**ENVIRONMENTAL ASSESSMENT EXHIBITION FOR MIXED USE BUILDING AT 6-16  
ATCHISON STREET, ST LEONARDS (MP09\_0187)**

Transport NSW has reviewed the Environmental Assessment (EA) report and appended Traffic and Parking Study (the 'Study'). The following comments are provided on specific aspects of the proposal and should be reflected in the final statement of commitments and potential future conditions of consent:

David Hartmann  
**A/ Senior Manager**  
**Centre for Transport Planning and Product Development**

Christie St

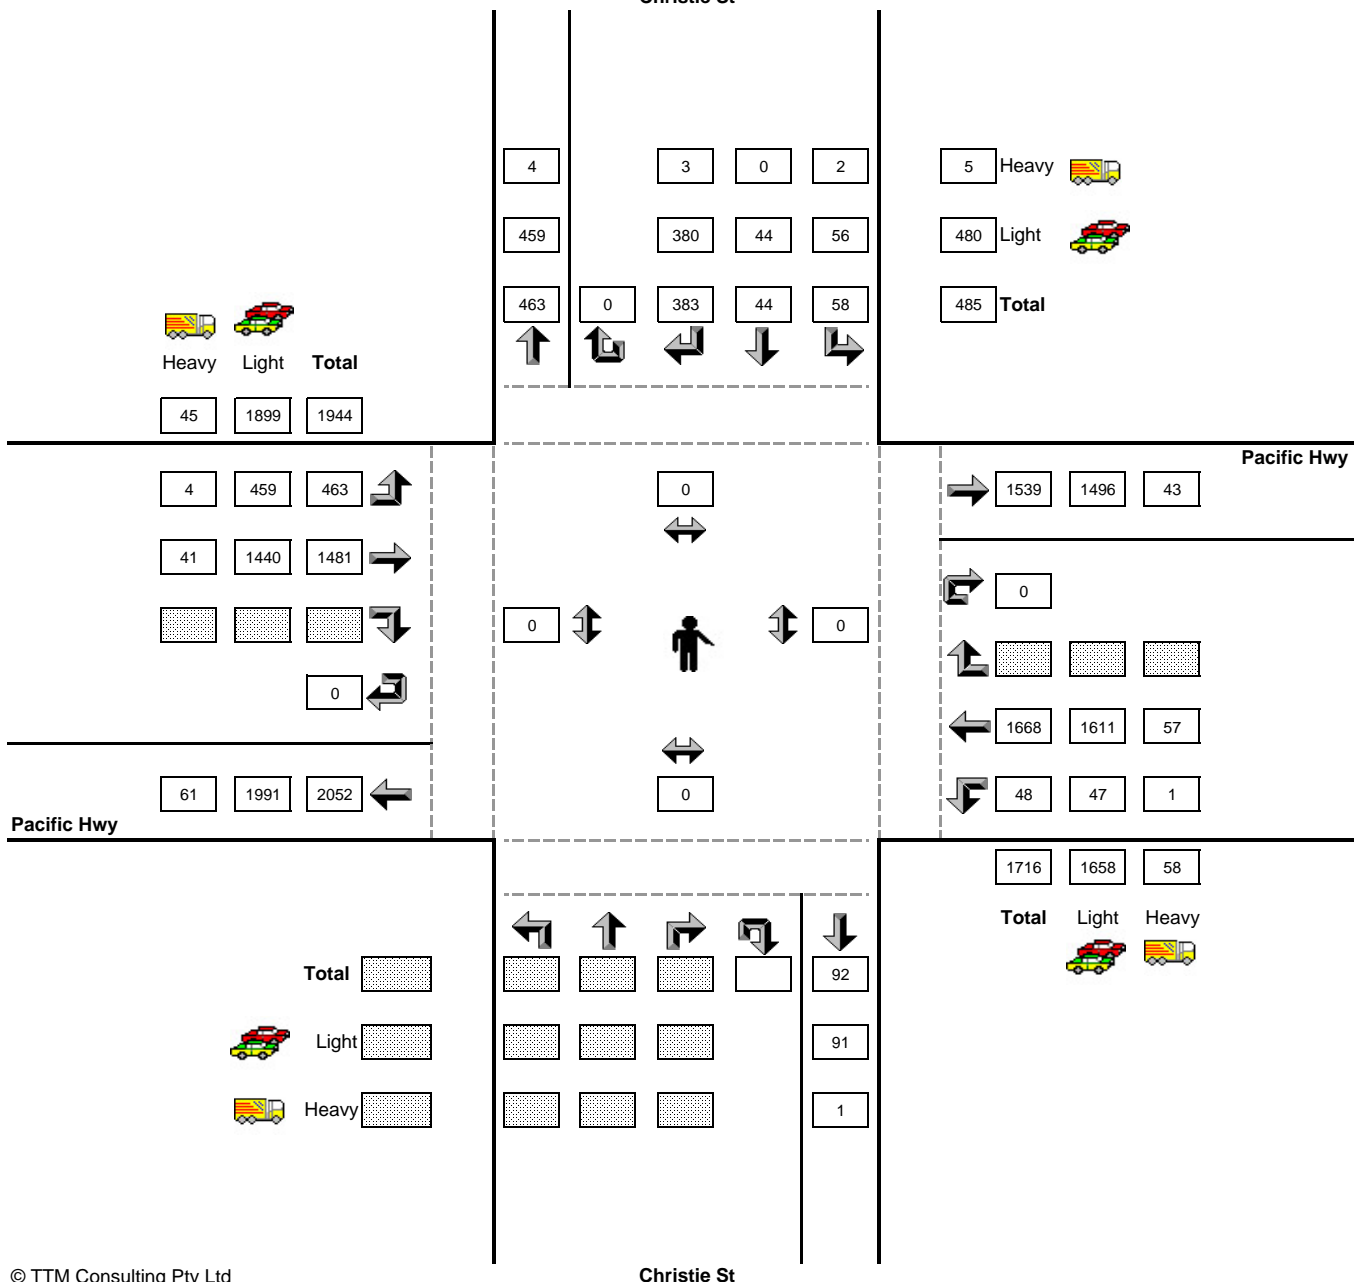
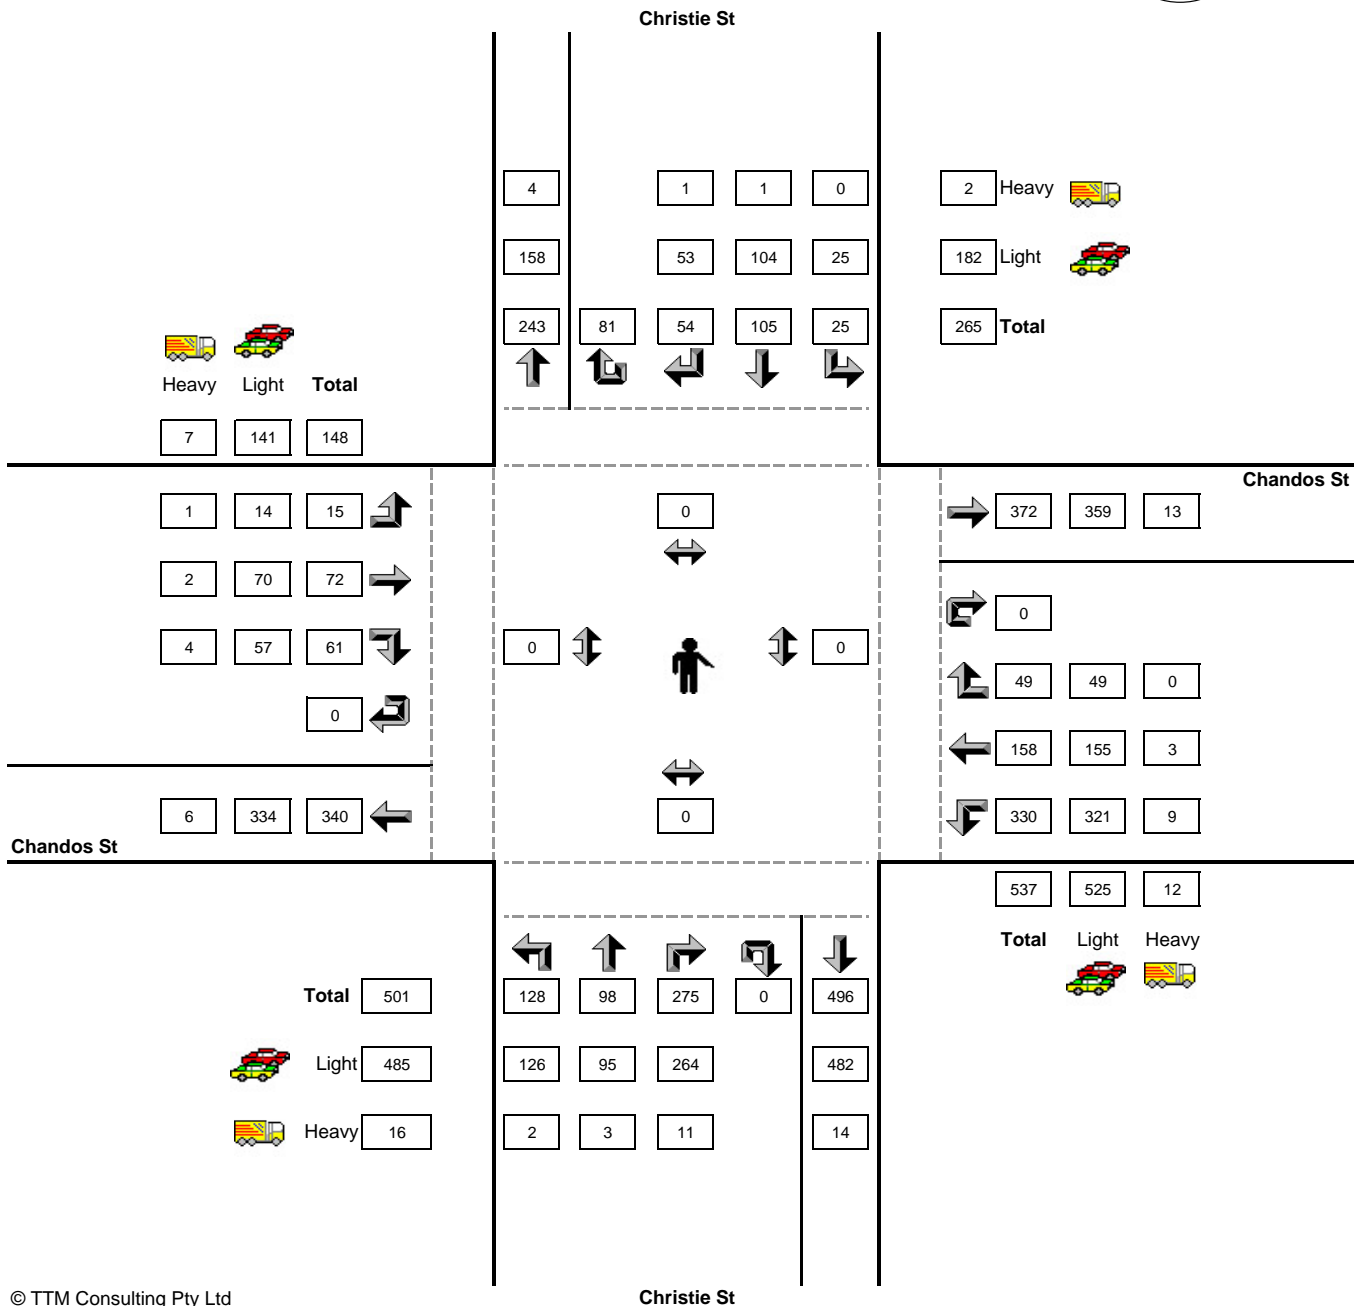
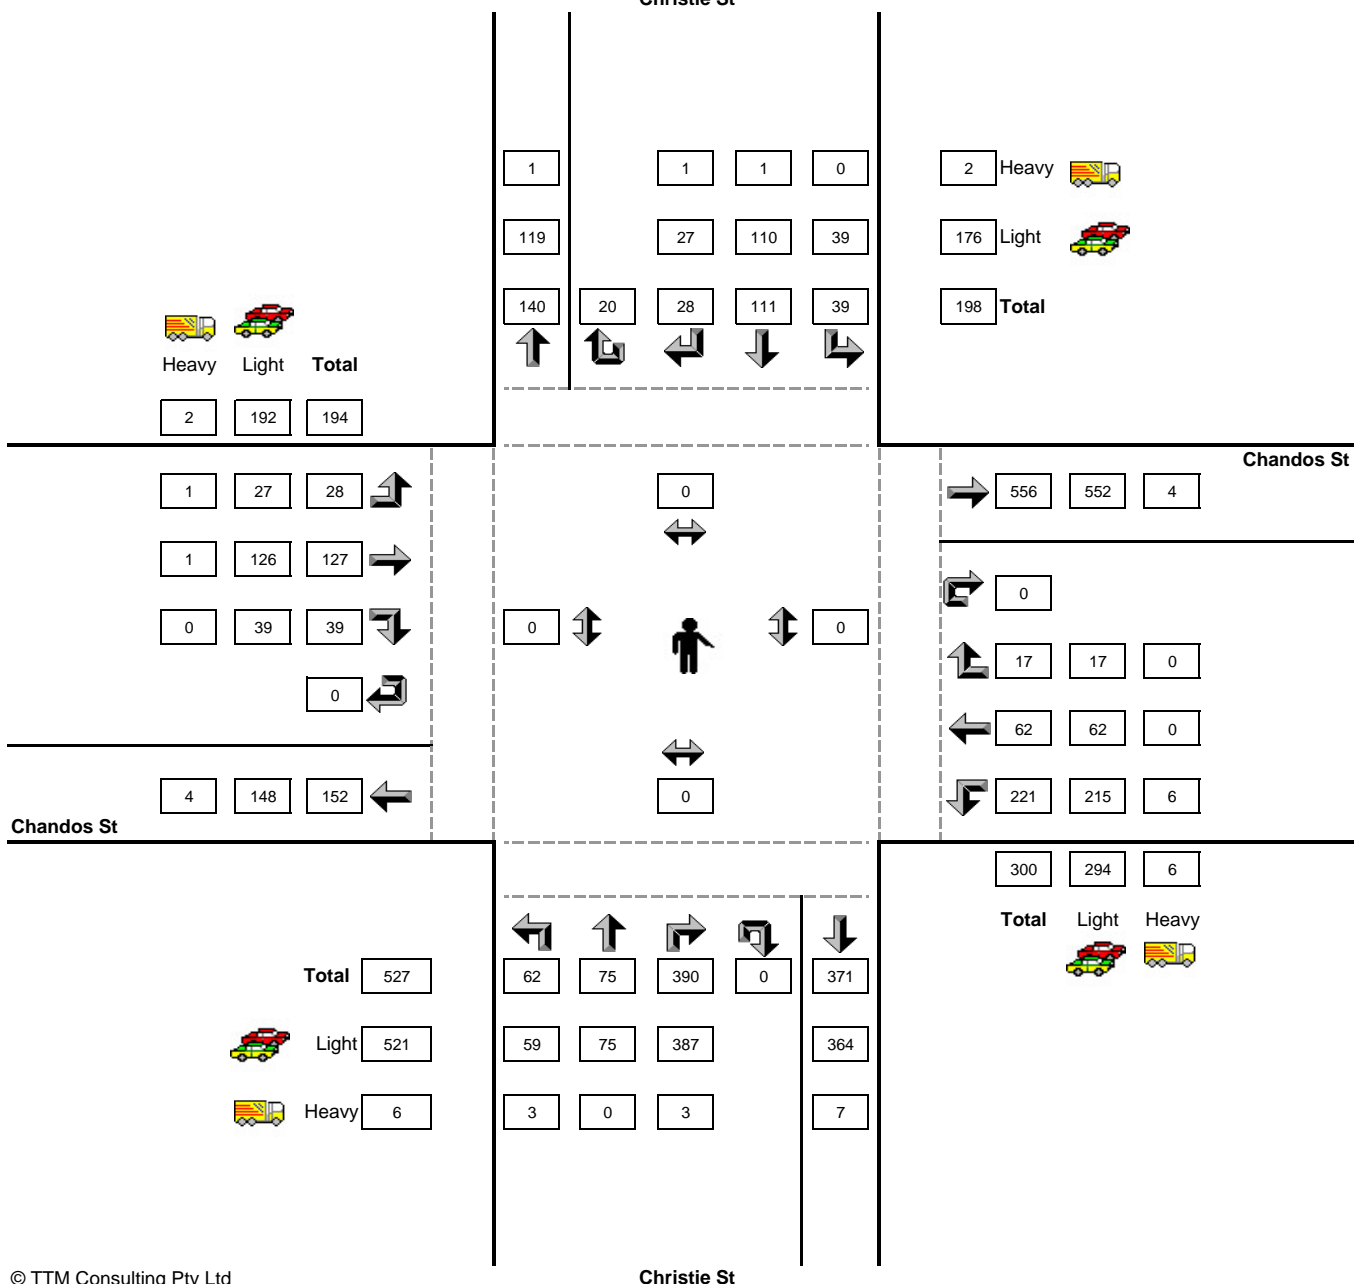
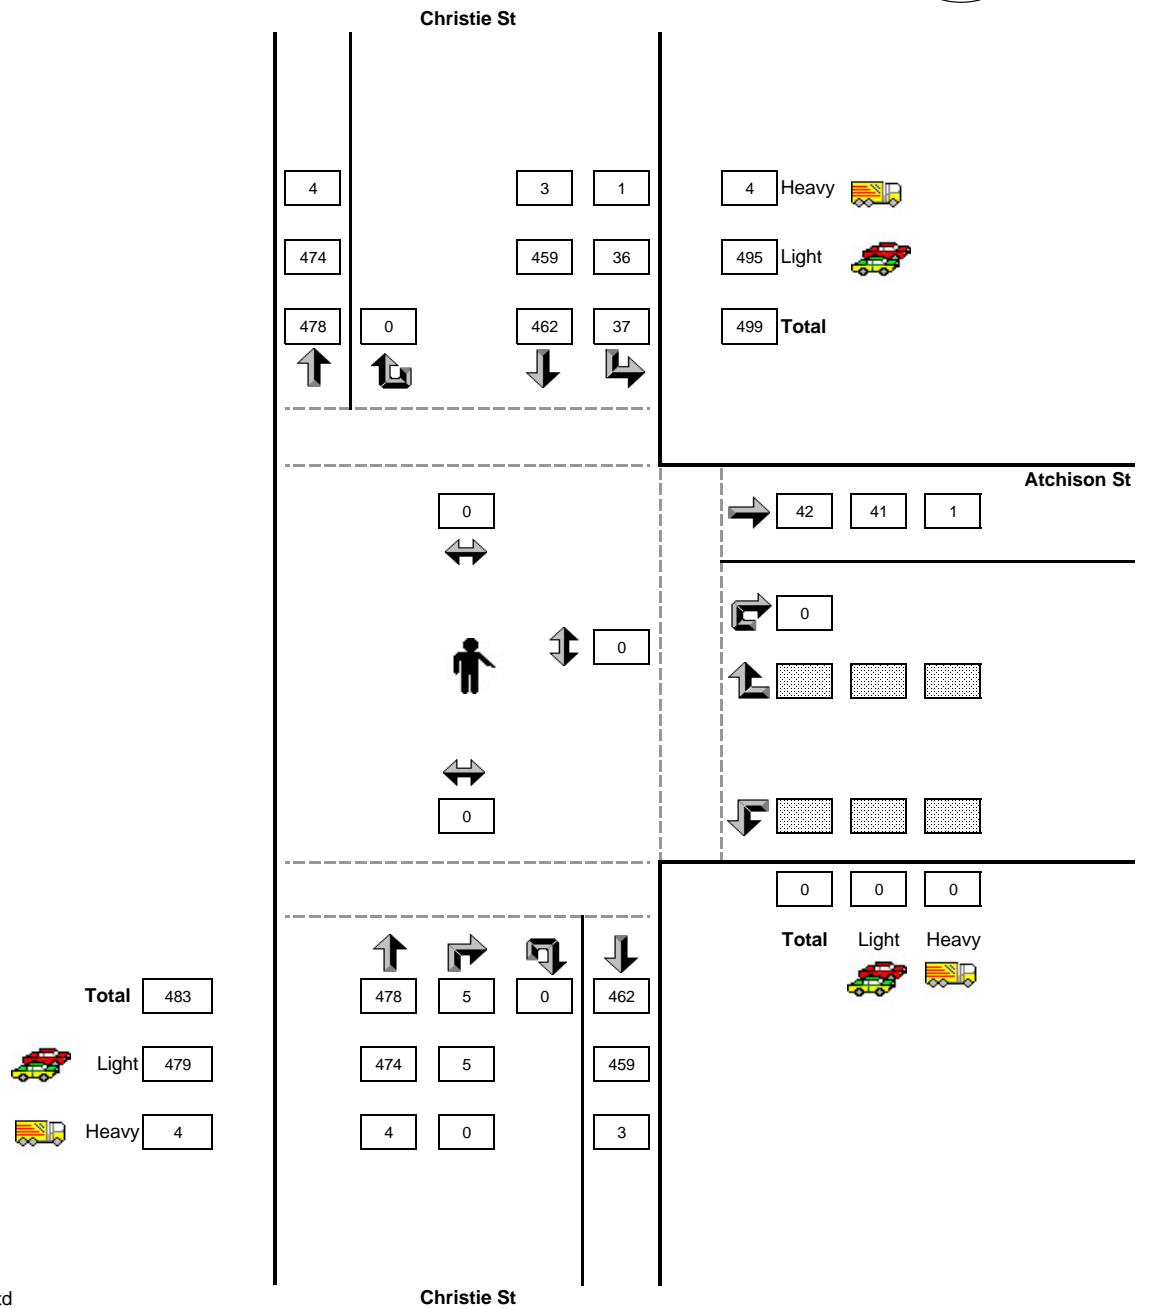
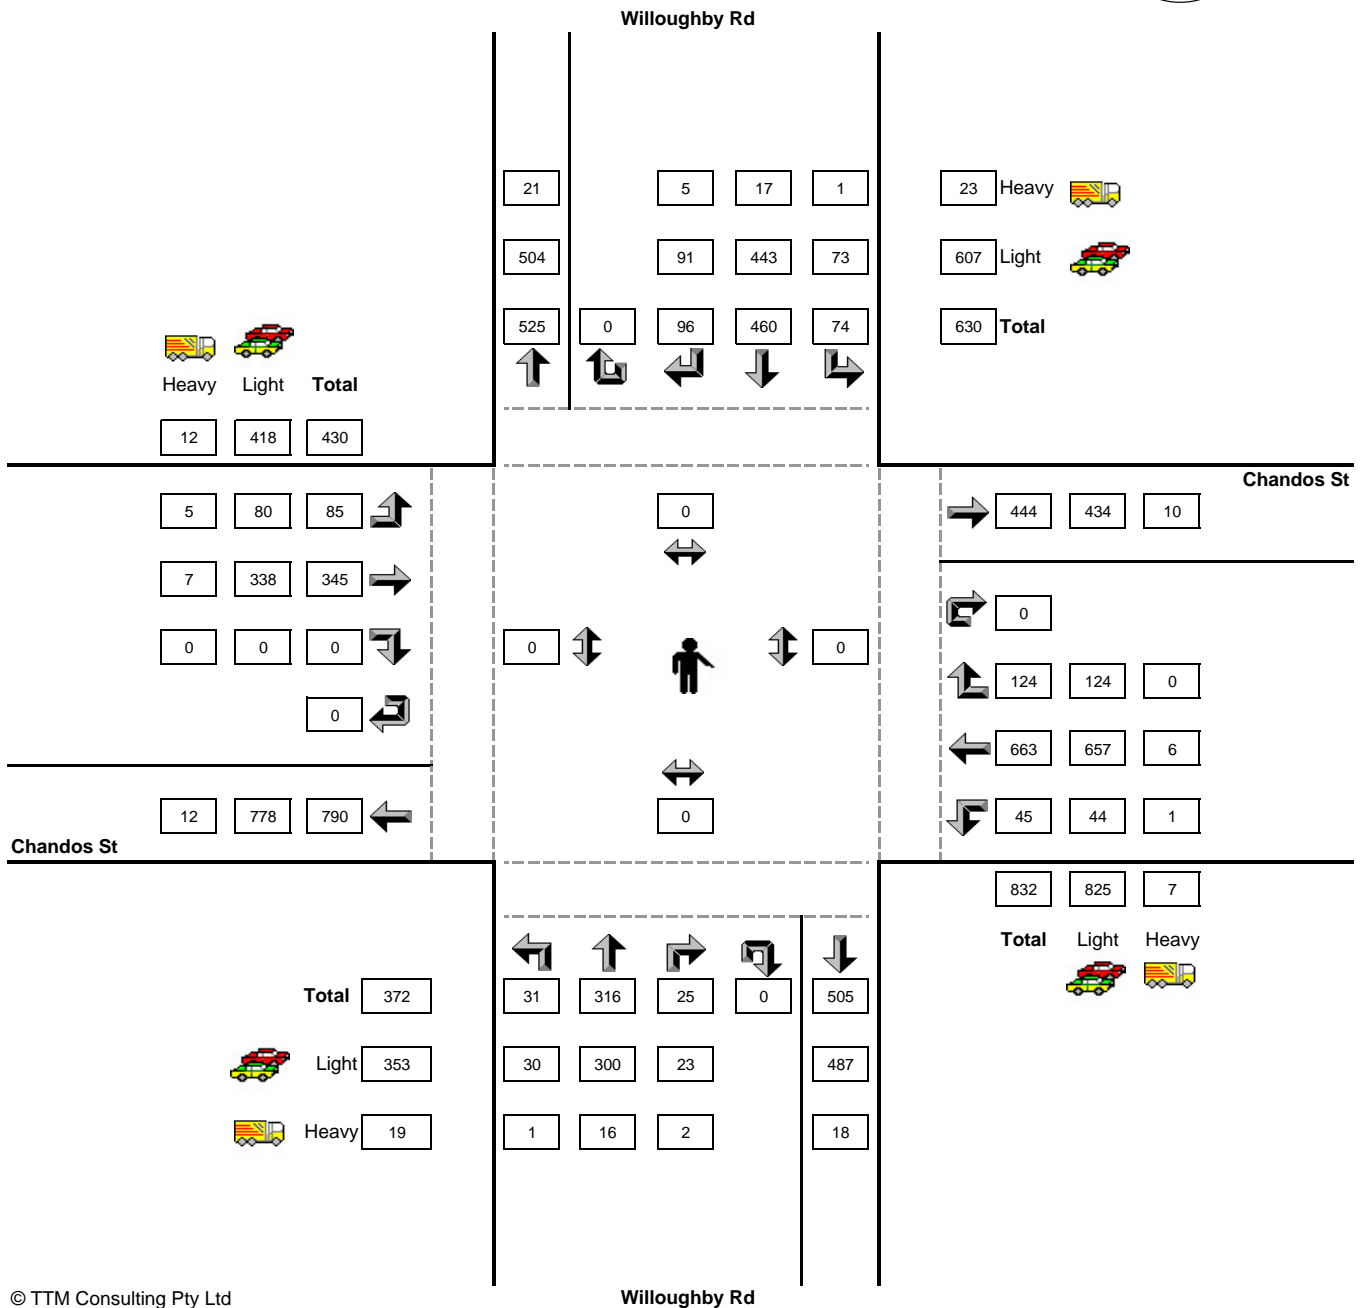
- Transport NSW queries the TTM Group pedestrian survey results that record no pedestrian activity within the survey period. Further consideration of pedestrian impacts and facilities is recommended.
